REVIEW RESPONSE

DATE: 11-30-2021
PROJECT NAME: SHL20-044 & SEP20-023_ SUN
RESPONSE TO:
CITY OF MERCER ISLAND – PLANNING DEPARTMENT
9611 SE 36TH STREET
MERCER ISLAND, WA 98040-3732

This letter is in response to the corrections SHL20-044 & SEP20-023. Below are our responses to the questions/comments from September 9th, 2021.

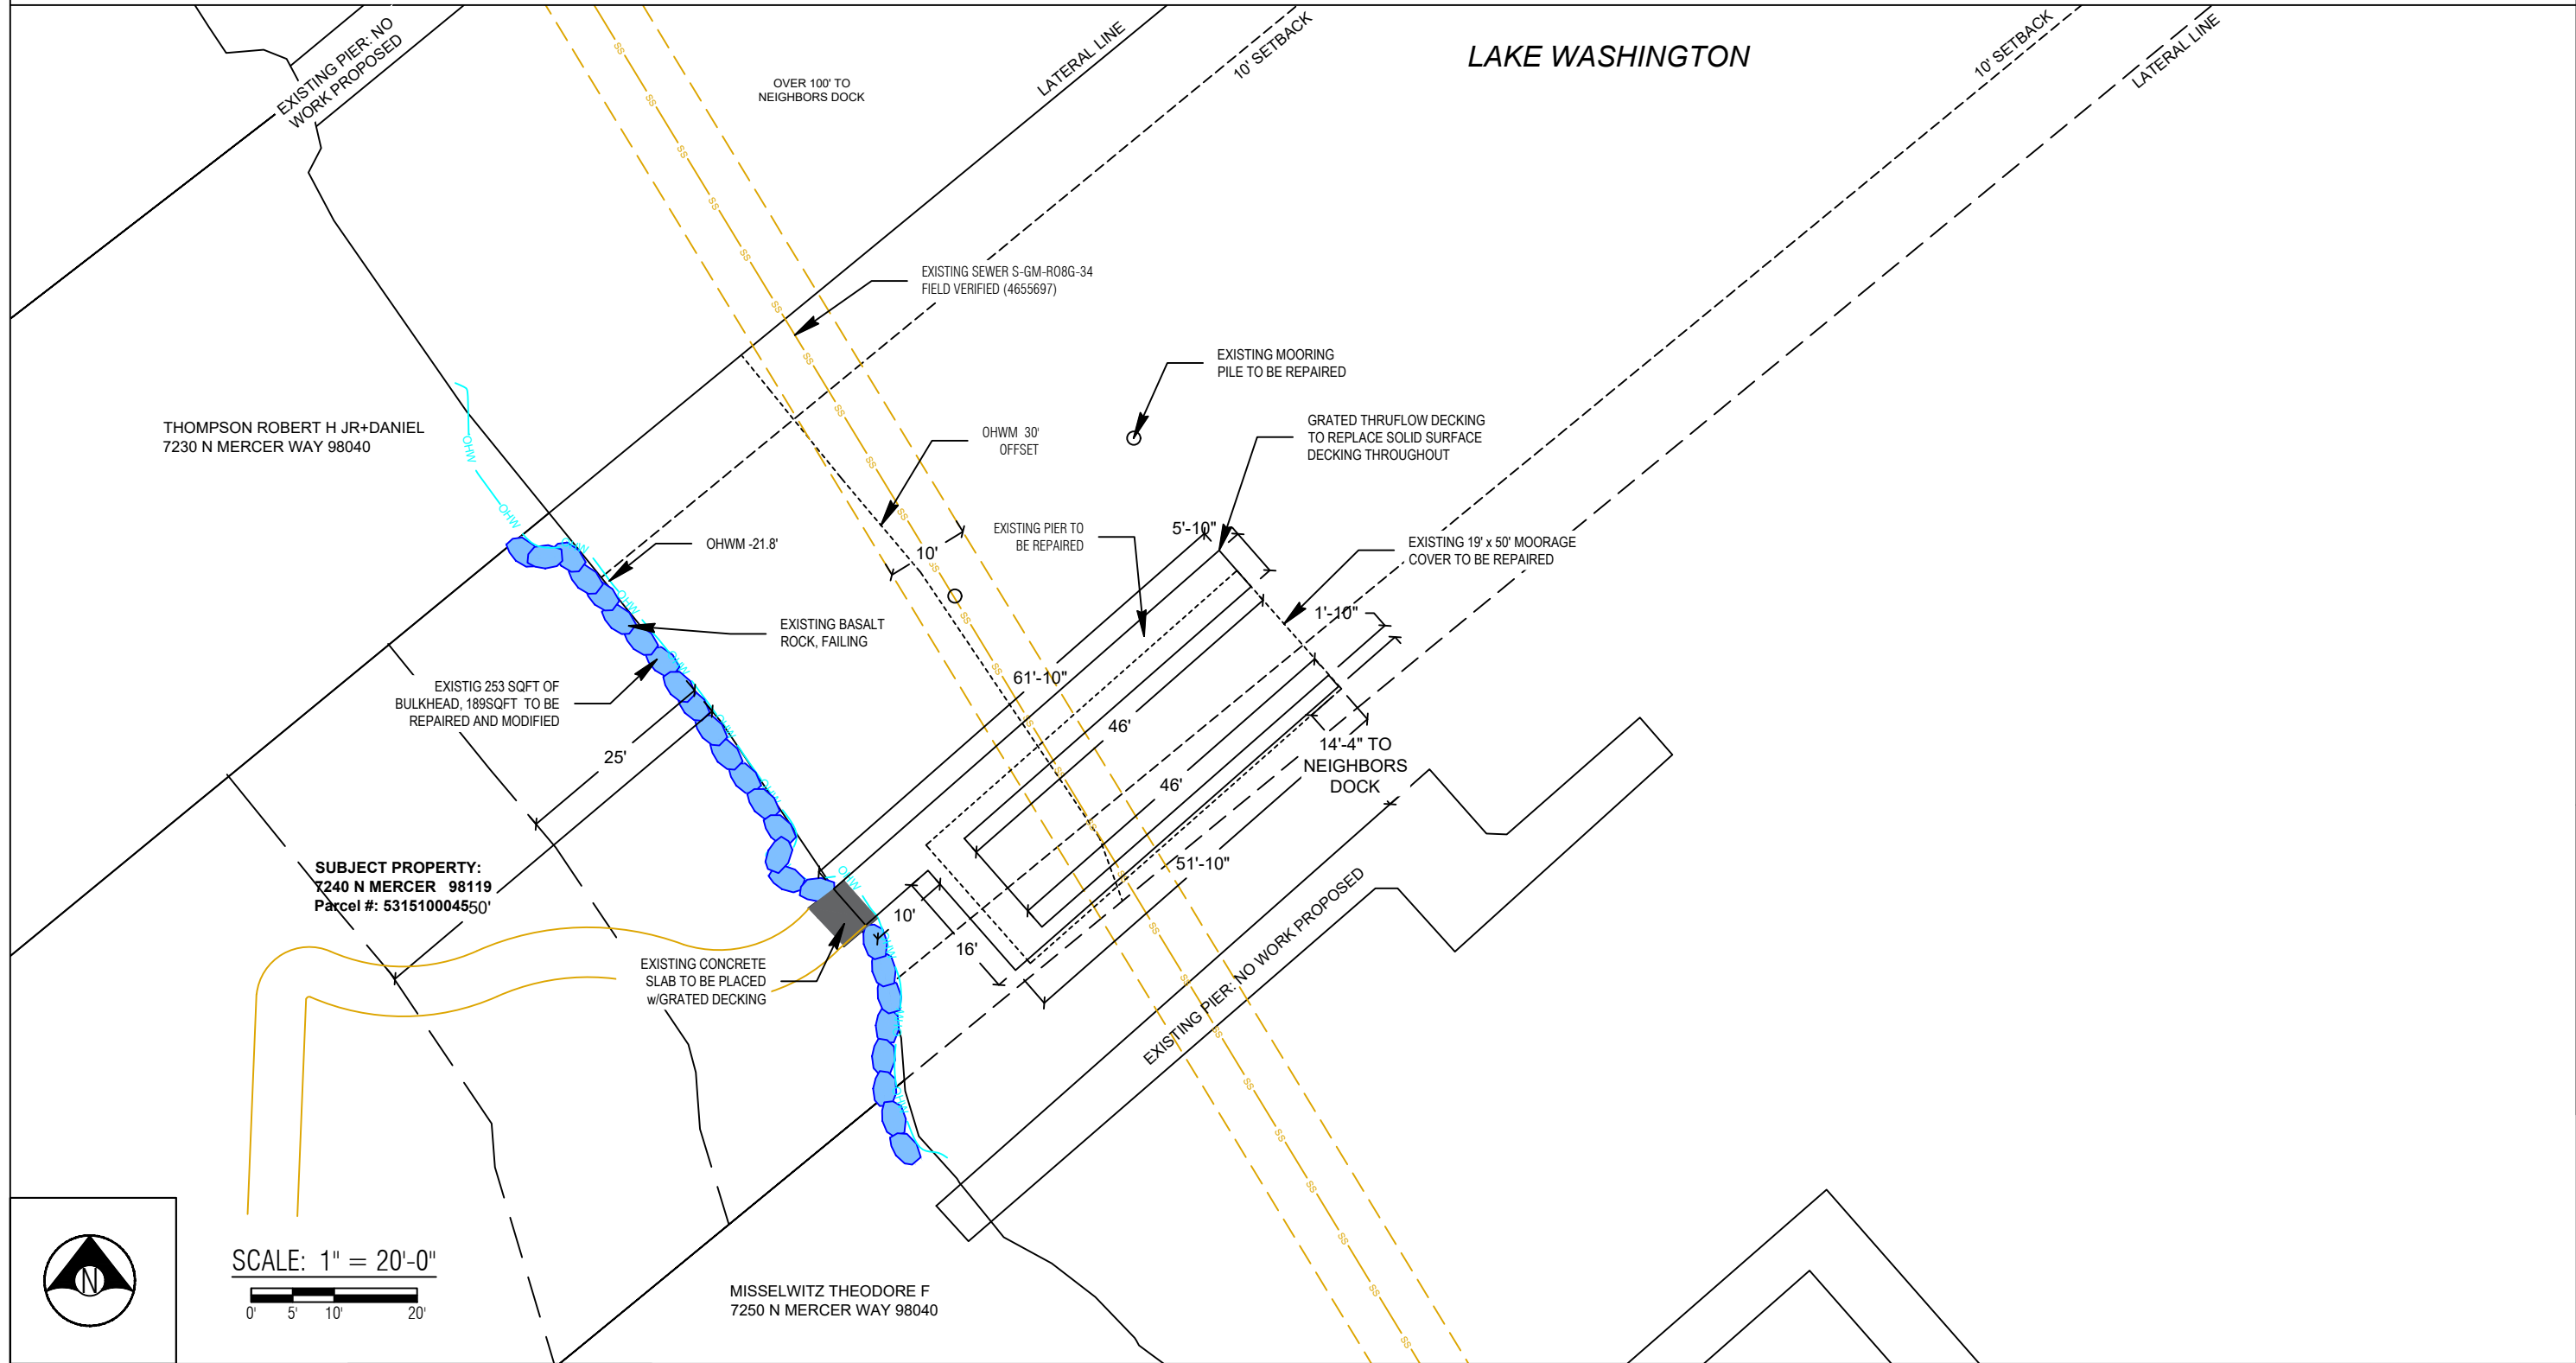
a. On sheet A2.0 please accurately show all existing structures on the plan. It appears that there is an existing covered moorage that is directly adjacent to the applicant's dock.

Updated plan set to show the neighboring moorage cover in a dashed line.

SHEET A3.0

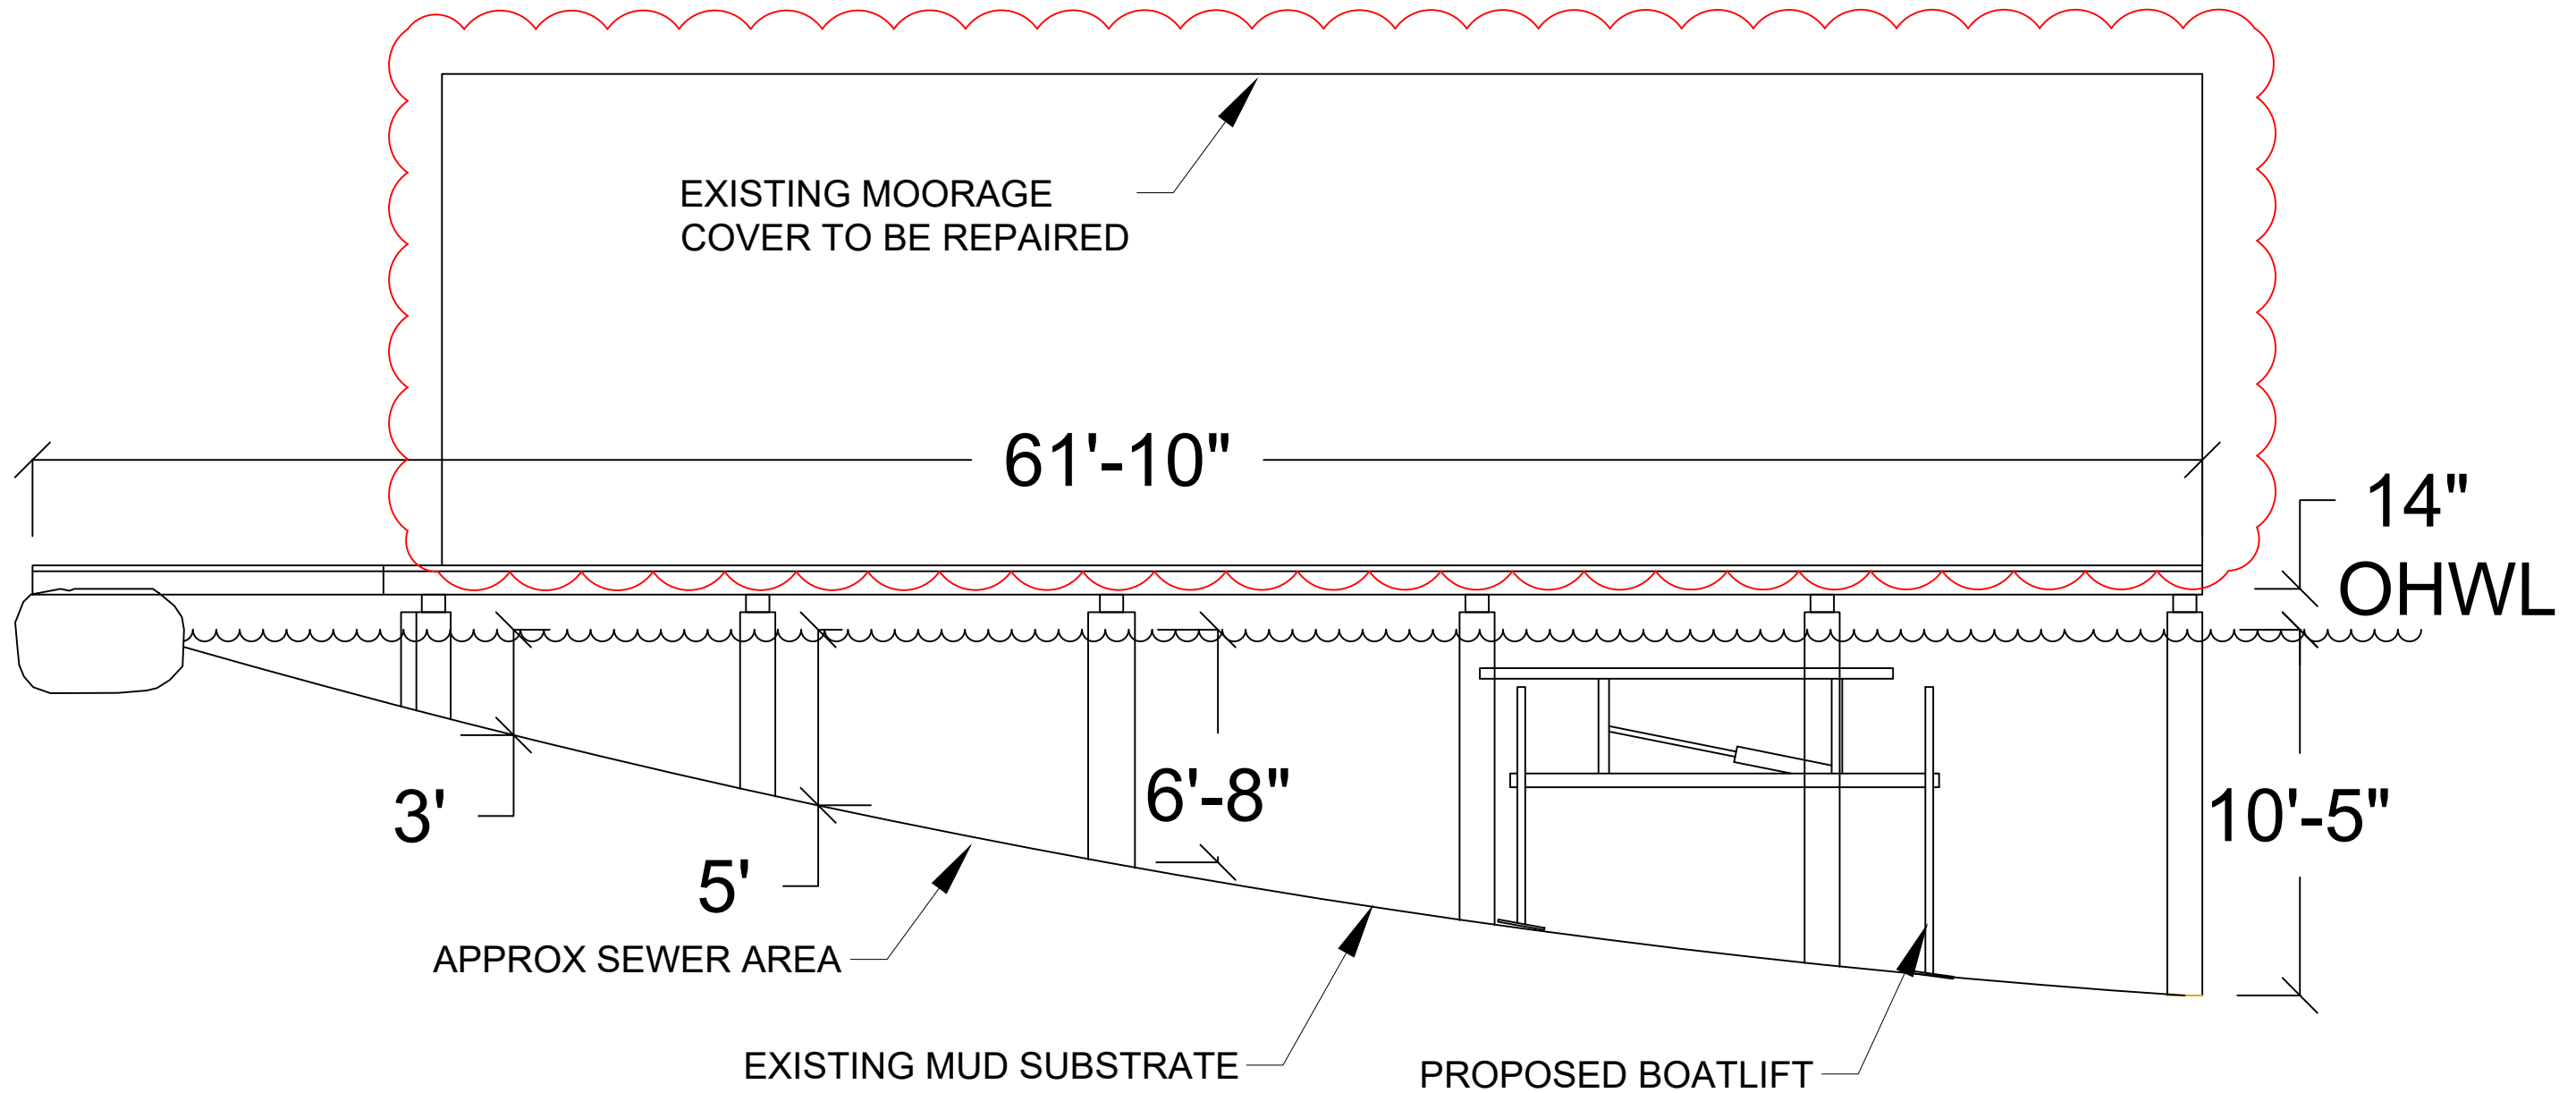
d. On sheet A2.0, the existing concrete slab is shown to be replaced with grated decking, but on sheet A3.0, the existing concrete slab is shown to be repaired. Please clarify what is planned for the existing concrete slab at the entrance to the dock.

Updated the plan set to show we are replacing with grated decking

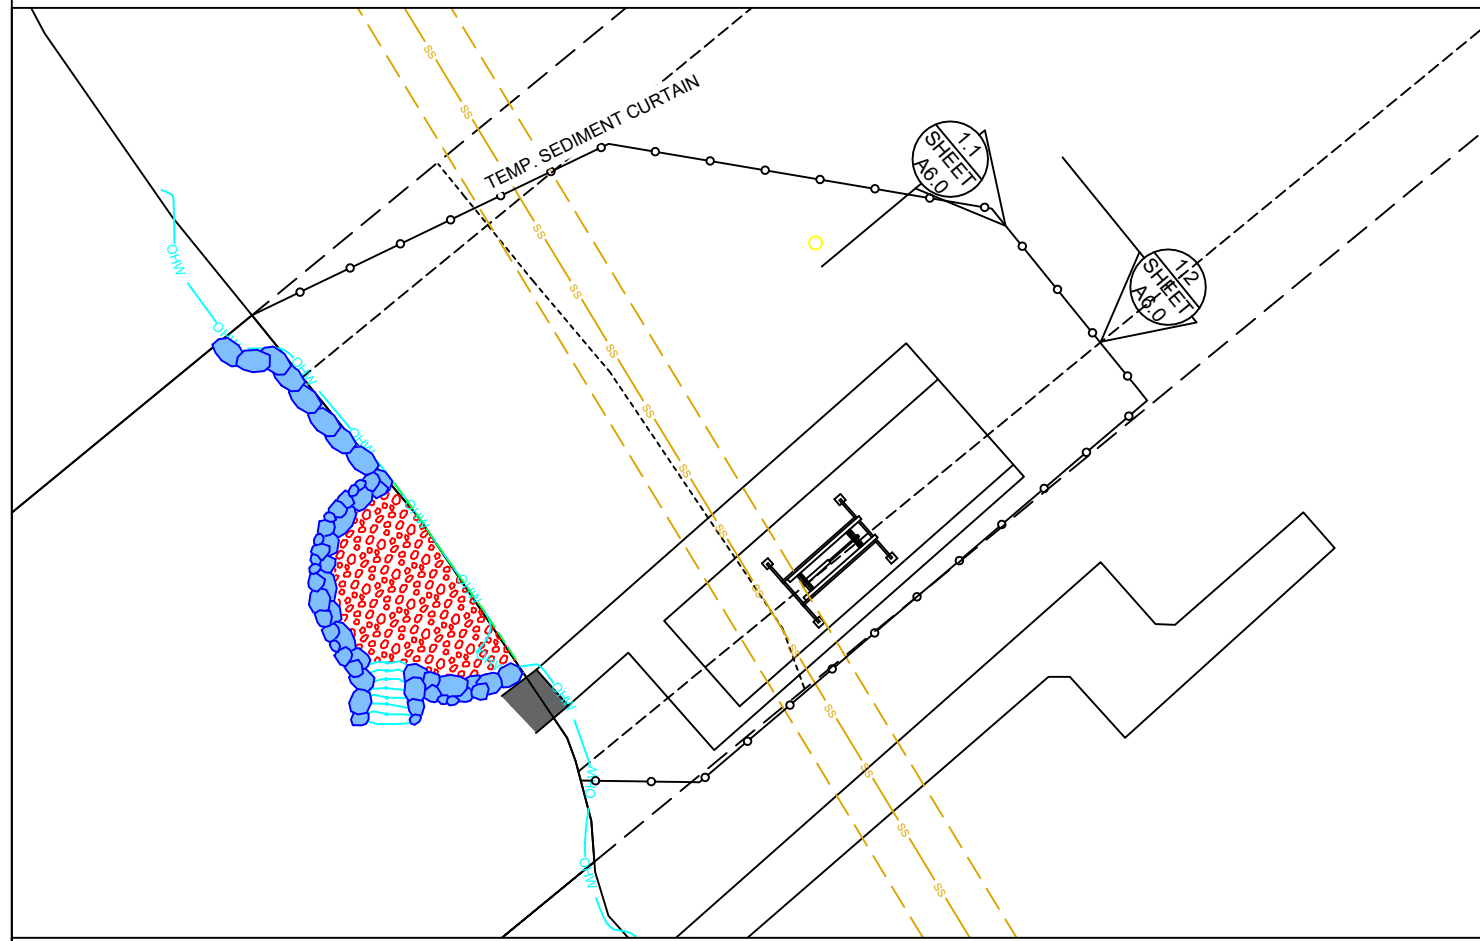
c. It is unclear on the plans (Sheet A4.0) which framing elements will be replaced as part of this project. Please show compliance with MICC 19.13.050 (F)(2) by showing on the plans an itemized list of all structural elements of the moorage facility that will be repaired or replaced (including the nonconforming covered moorage repair that has been recently added to the scope of the project). Then please show compliance with the 50% threshold for repair and maintenance of ALL structural elements (including stringers, piles, pile caps, attachment brackets, and all structural elements of the covered moorage).

d. Sheet A4.0 shows that 10 of the existing piles will be repaired as part of this project. However, on sheet S1, it shows that 19 of the existing piles will be repaired. Please make sure that the proposed drawings are accurate and consistent.

Updated the plan set to show the member count for the dock. Since the moorage cover is no longer being repaired, I did not include those members.

Updated the plan set to show the member count for the dock on Sheet A4.0 which will allow us to repair (19) piles. I have updated the scope of work and the pile count legend to reflect this.
